Conservation Area Advisory Committee

Meeting Date : 8th September 2010

1:1250 Location Plan

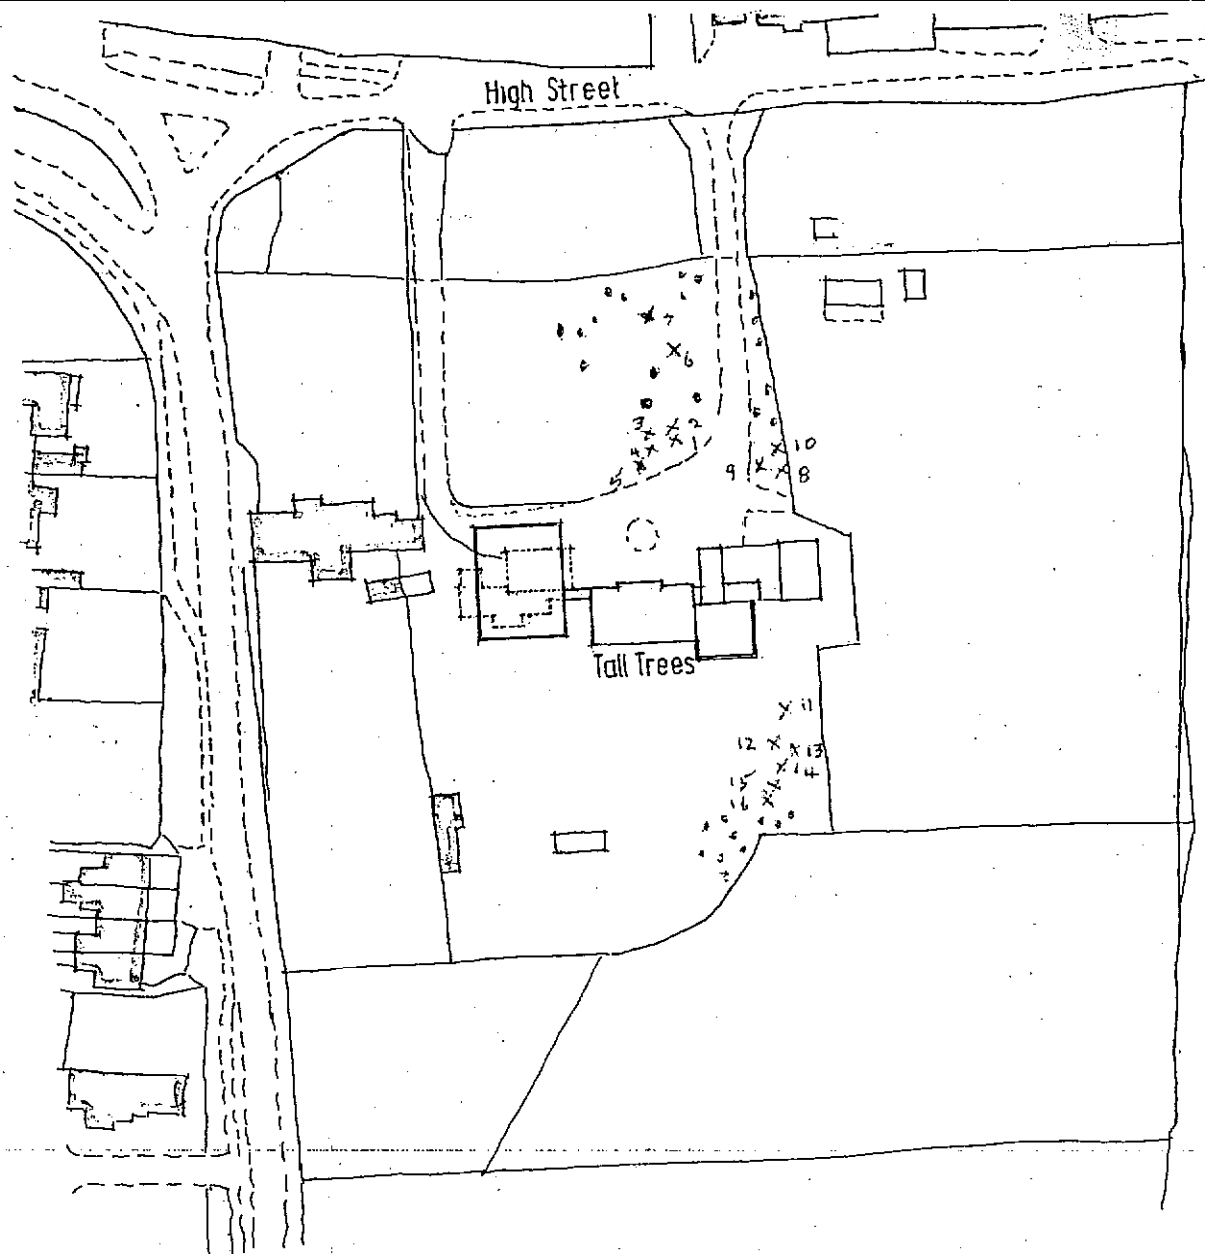
App No	Description/Address	Comment	Recommendation/Observation
A/118/10/TC	Tell 4No. Cherry trees, 6No. Cupressus, 2No. Sycamore, 3No. Apple trees and 1No. Rowan tree within the Angmering Conservation Area. Tall Trees High Street Angmering	Objection	We would refer to arboriculture to look at effect of loss of such a large number of trees.
